Final Report - Corrections Required **Application No. ANEX-24-0007**

Description : Matrix Design Group on behalf of Colorado Springs Equities LLC is submitting a serial annexation petition for seven parcels and Land Use Plan/Rezoning exhibit for a portion of the subdivision known as Rock Creek Mesa.

Document Filename : Rock Creek Mesa Addition No 6_Legal Description_V3_5-13-24

ANNEXATION PLAT

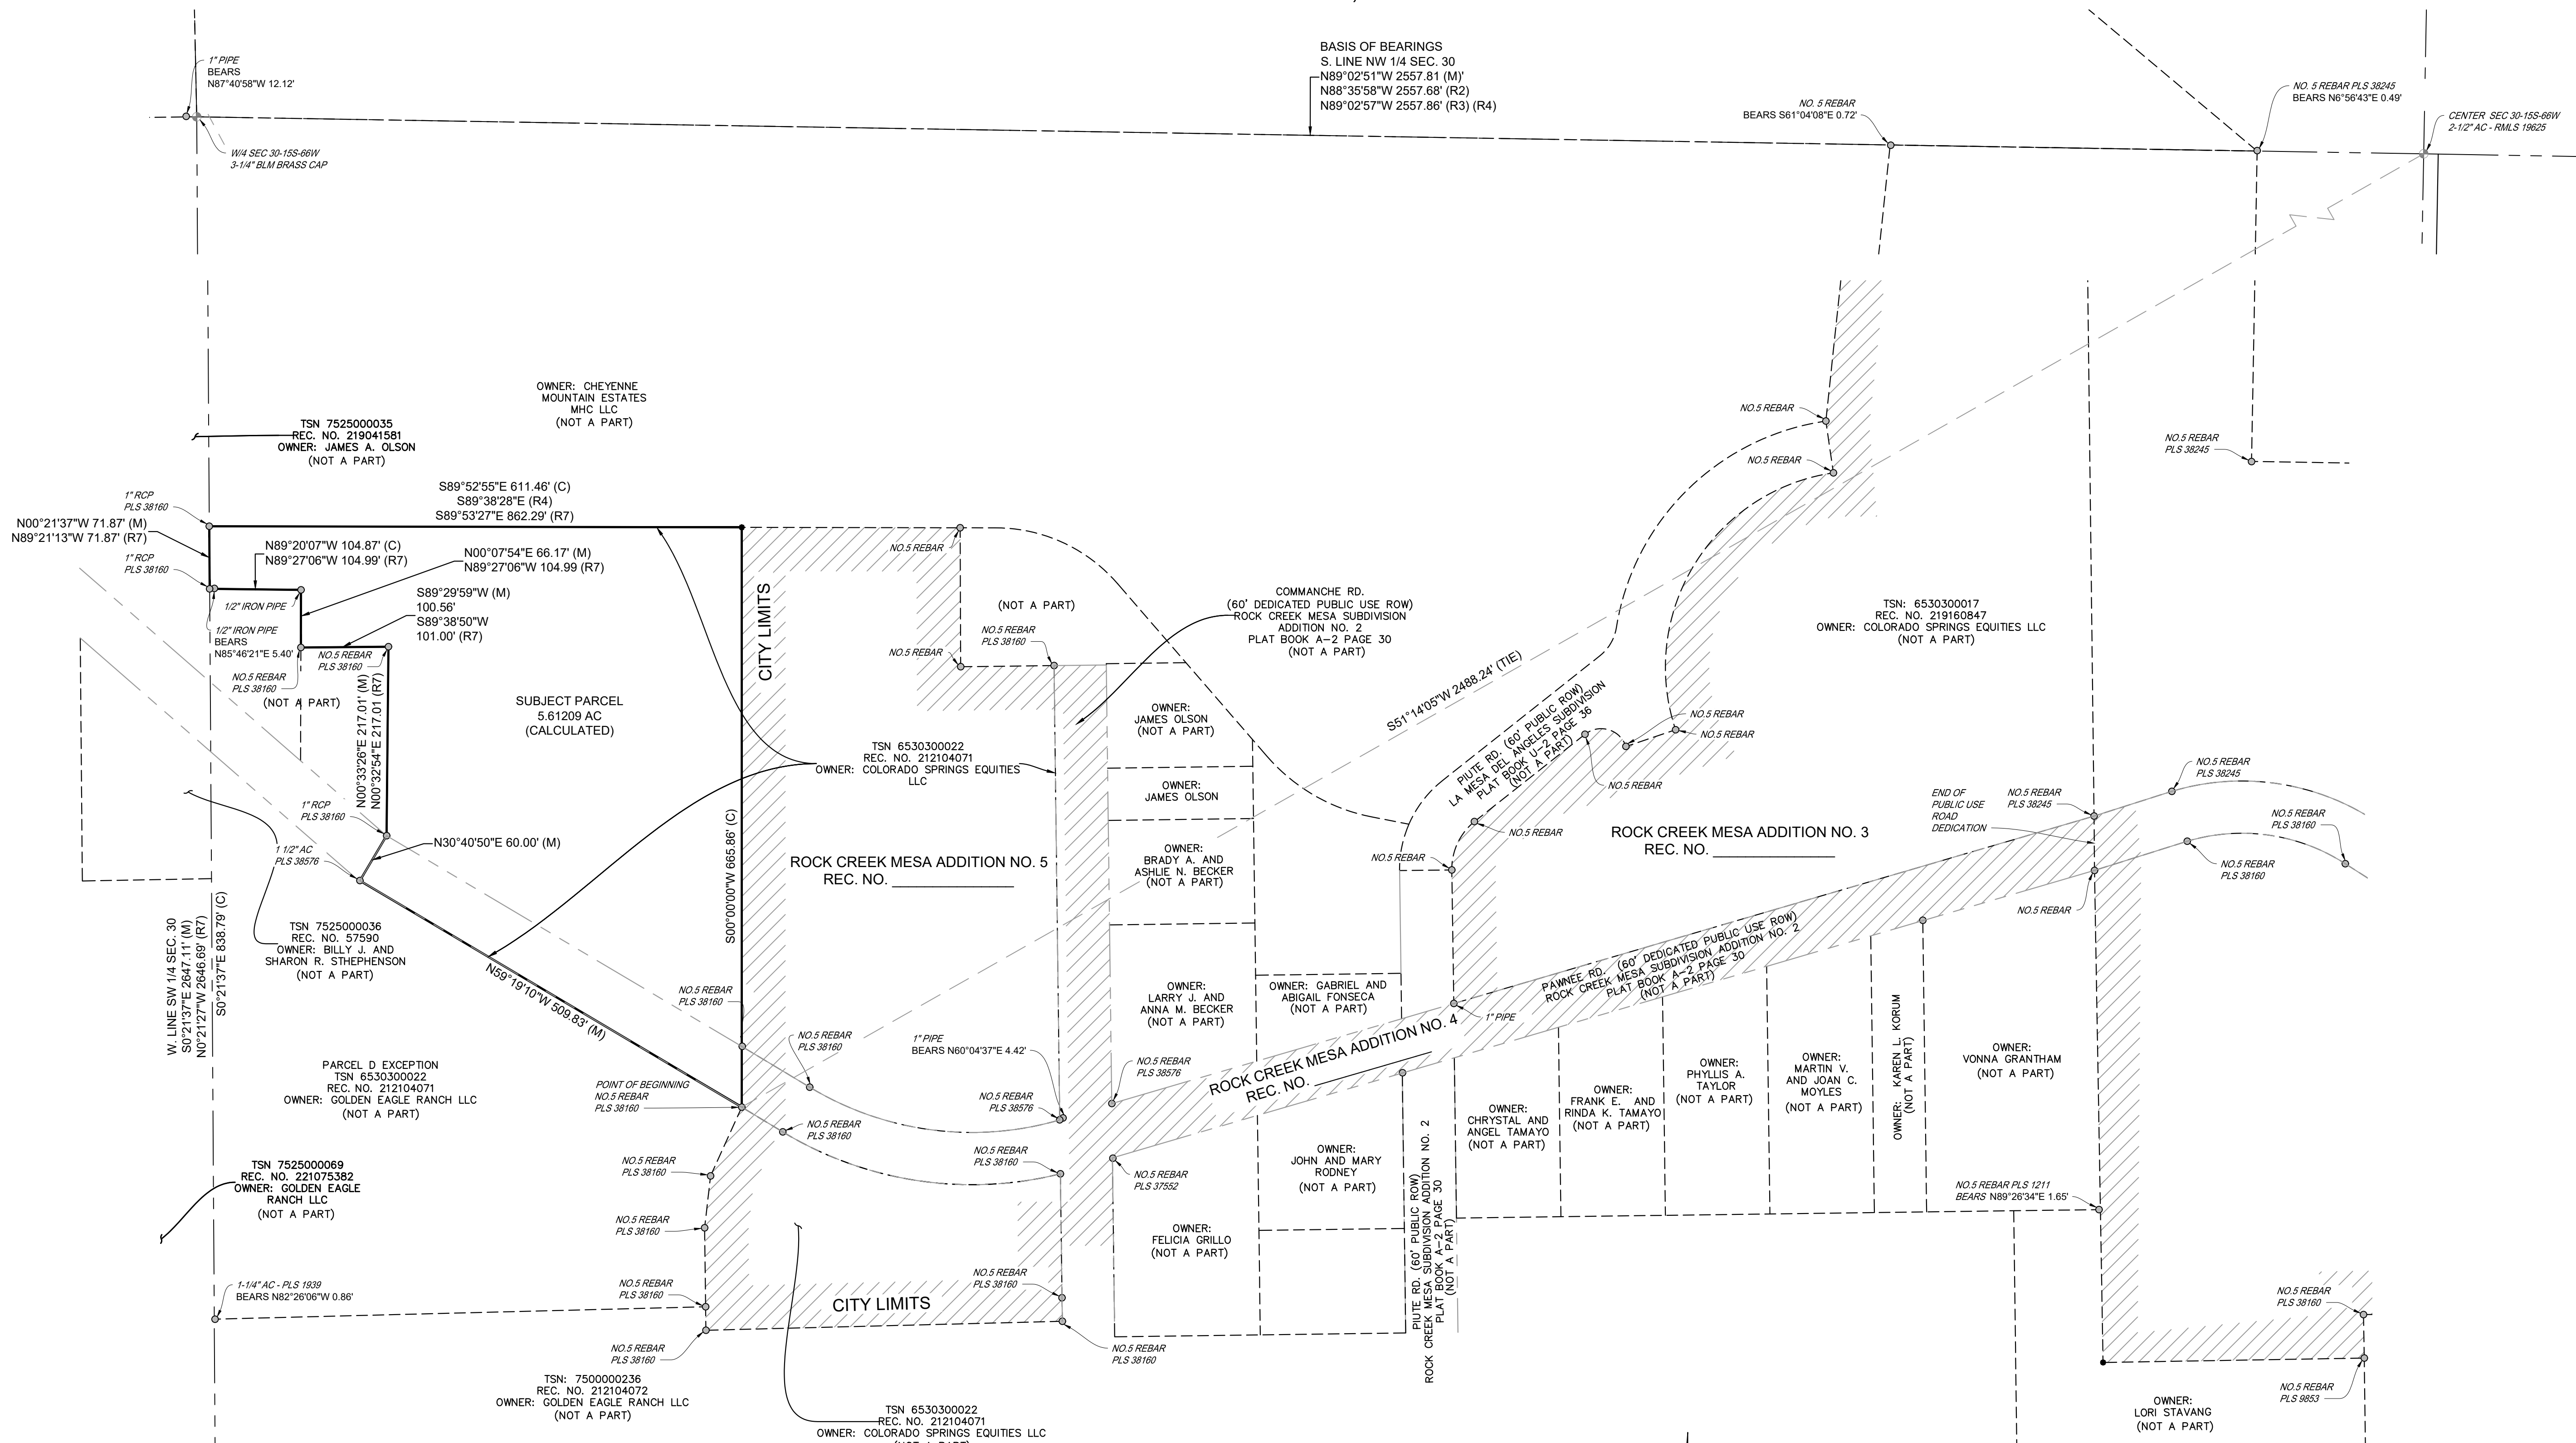
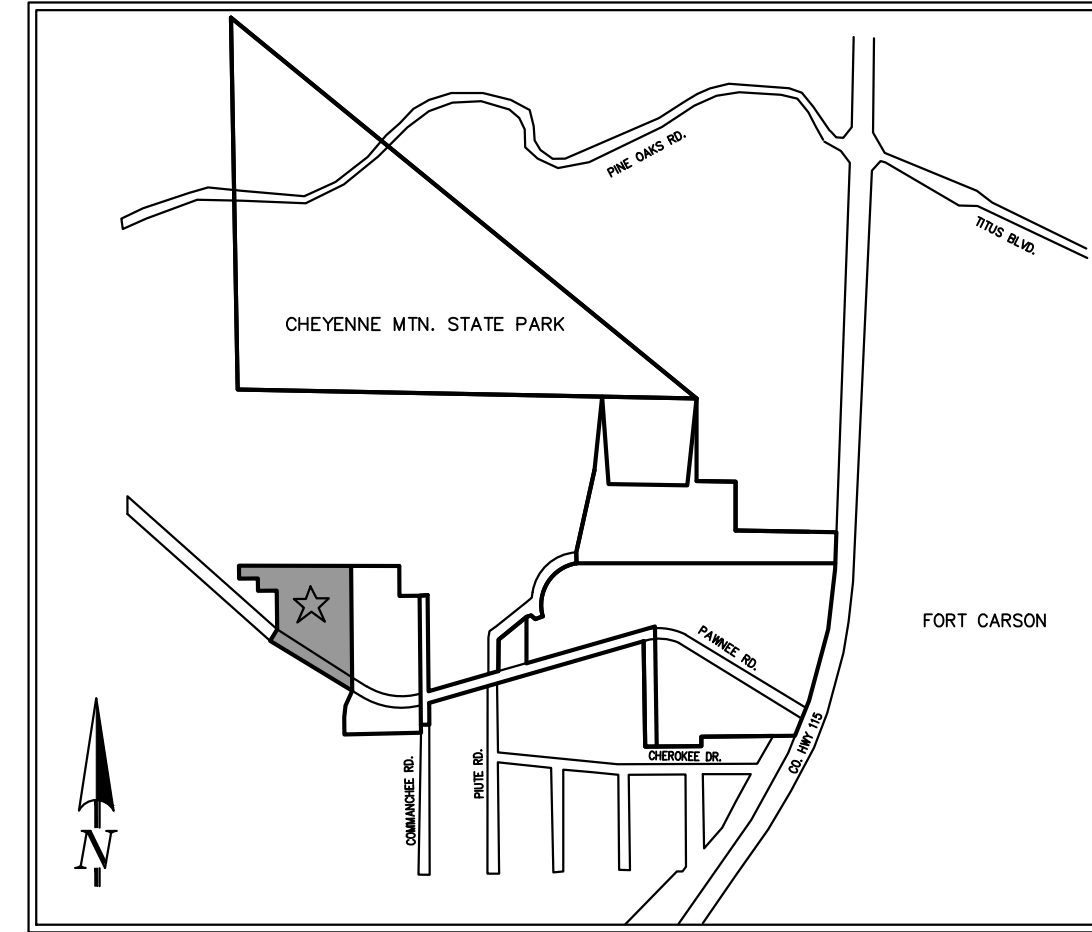
Comment ID	Page Reference	Reviewer : Department	Review Comments
45	1	Cory Sharp : Planning	please revise per annexation plat comments
